Traffic Impact Studies

Job number: 2023-8-1-Varko

Traffic Memo for 1185 N Curtis Rd

**SHEET NUMBER:**  
**S-2**

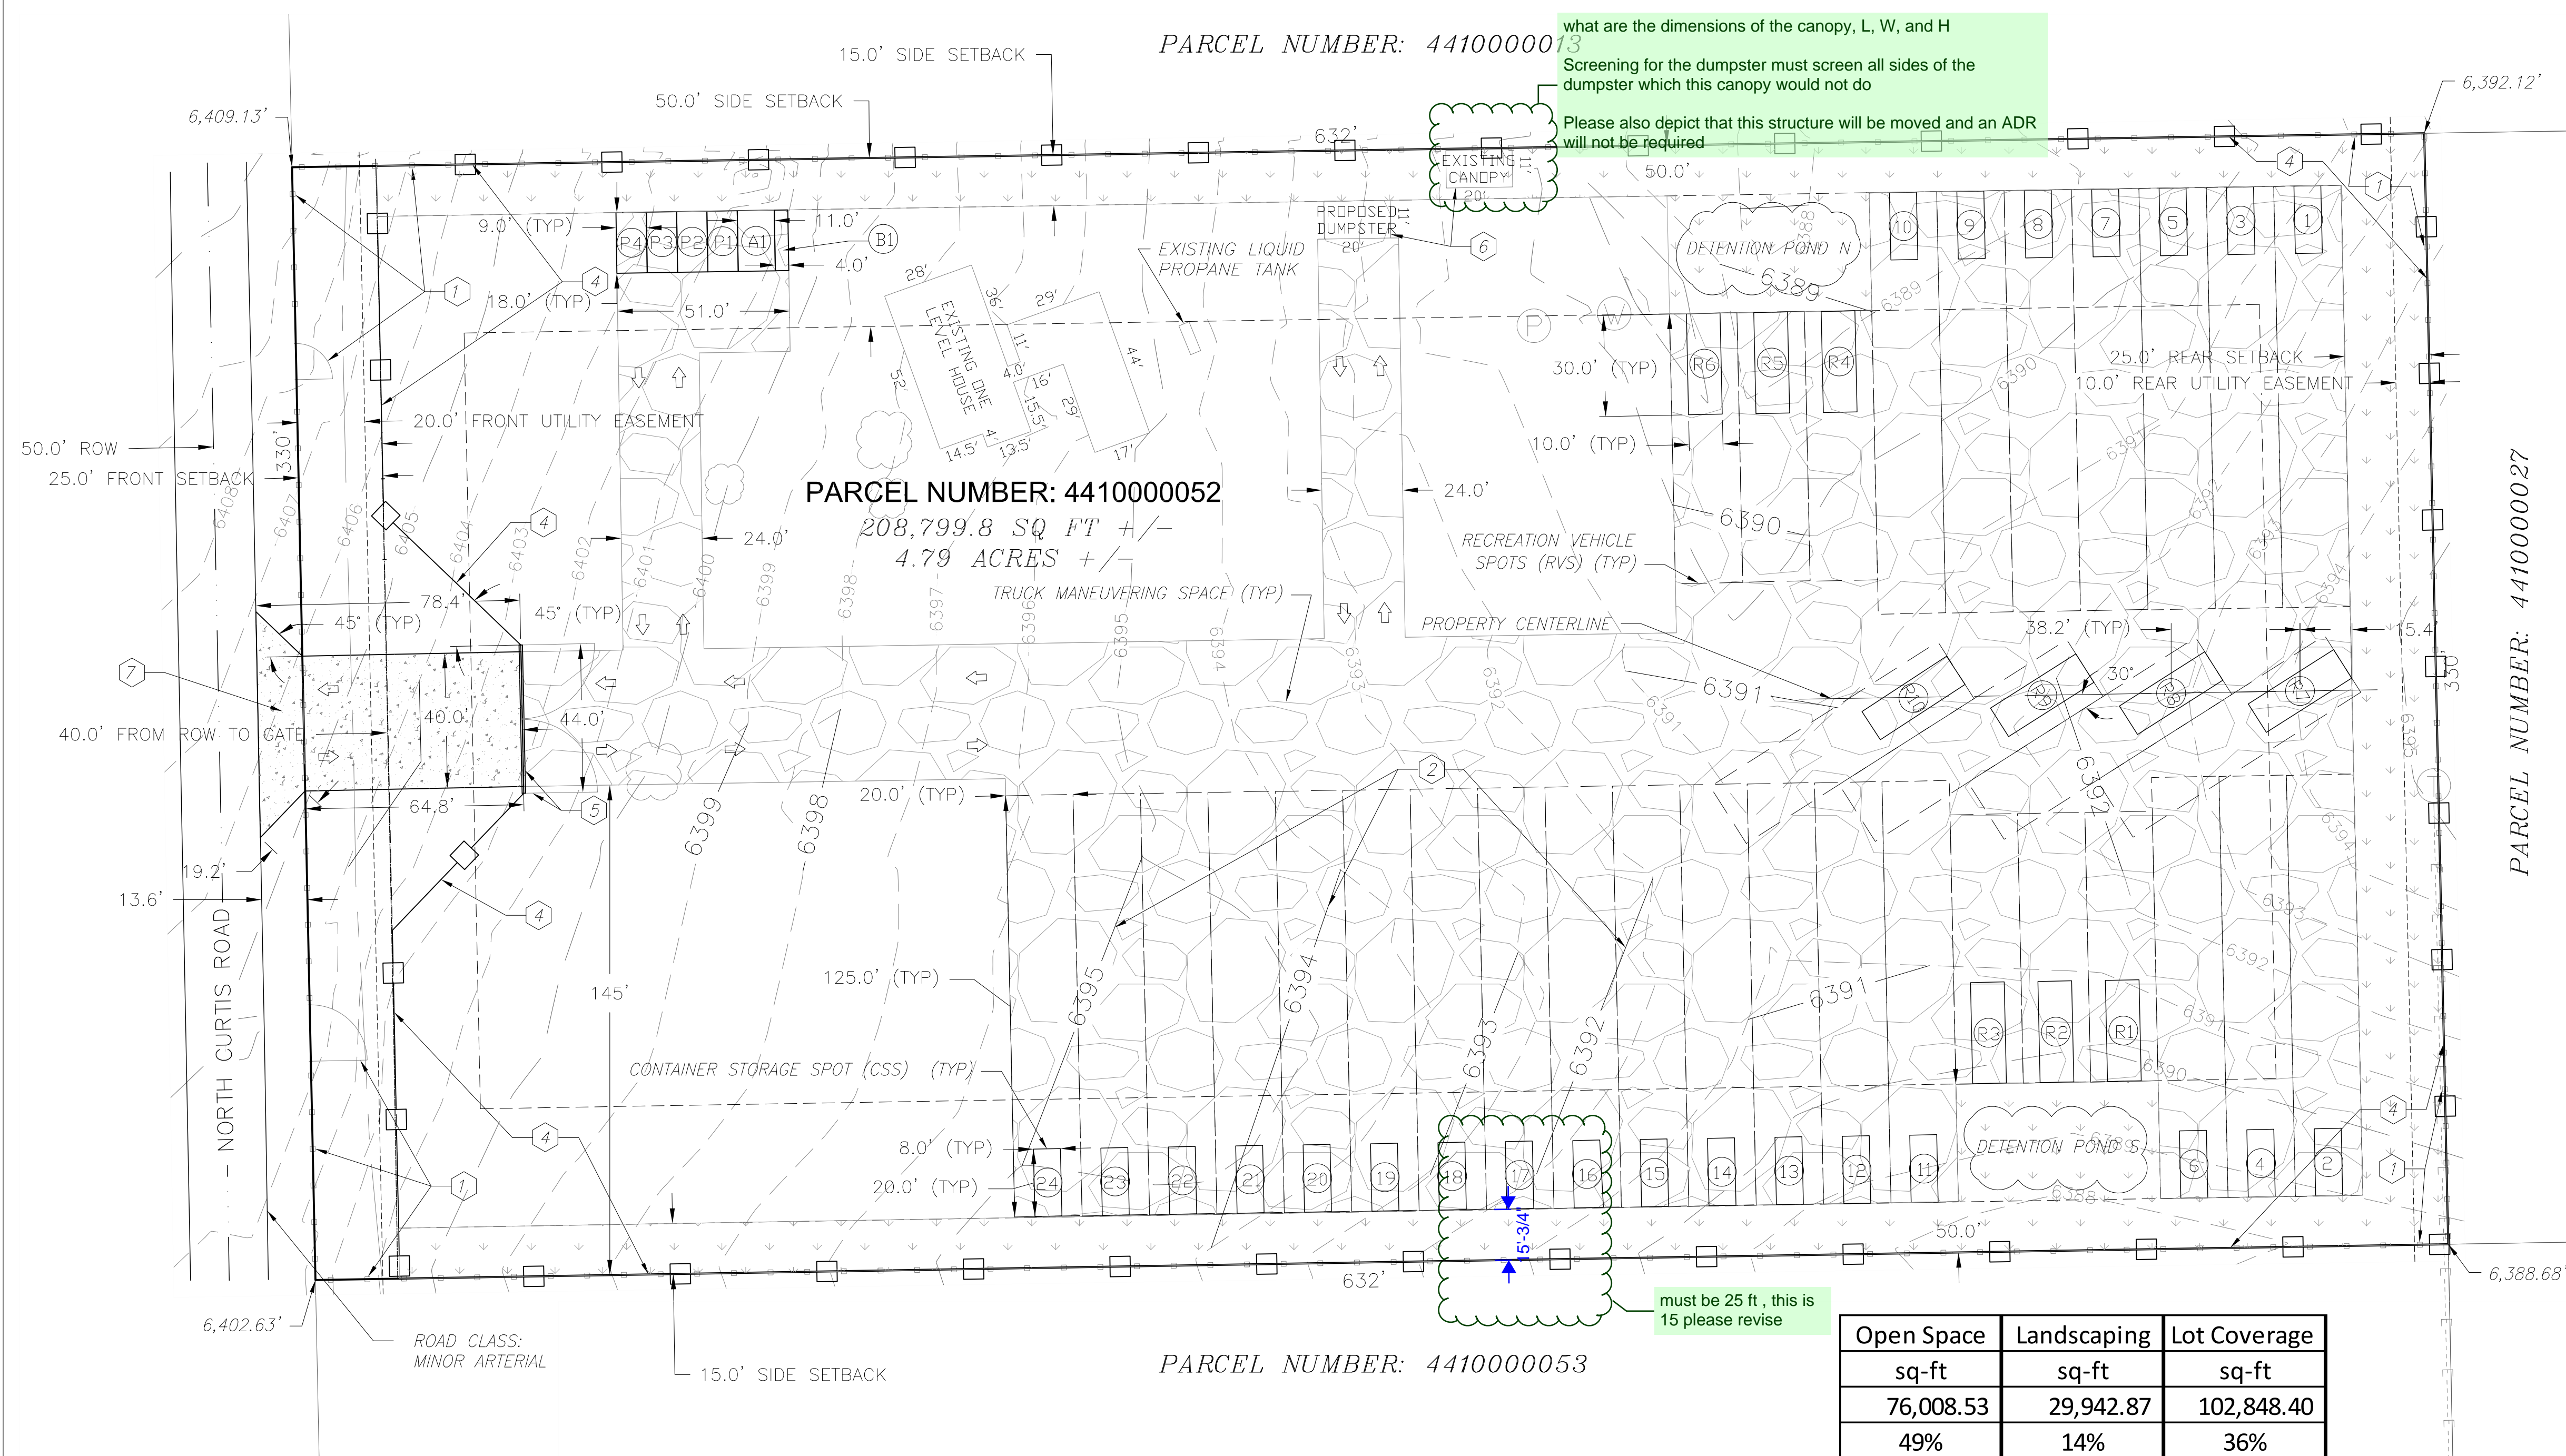
Gravel shoulders are not permitted parking areas along arterial. Revise overall. Address requirement for turn lane base on site condition and ECM requirements.

Provide alternate plan for turning vehicles.

Vehicles are not permitted to park along an arterial roadway. Any gates must be set back from ROW as detailed in the LDC for proper setback to not block the ROW. Gate Location and Dimensions. Gates shall be located a minimum of 30 feet from the public right-of-way and shall not open outward. The opening provided through a gate shall be 2 feet wider than the traveled way.
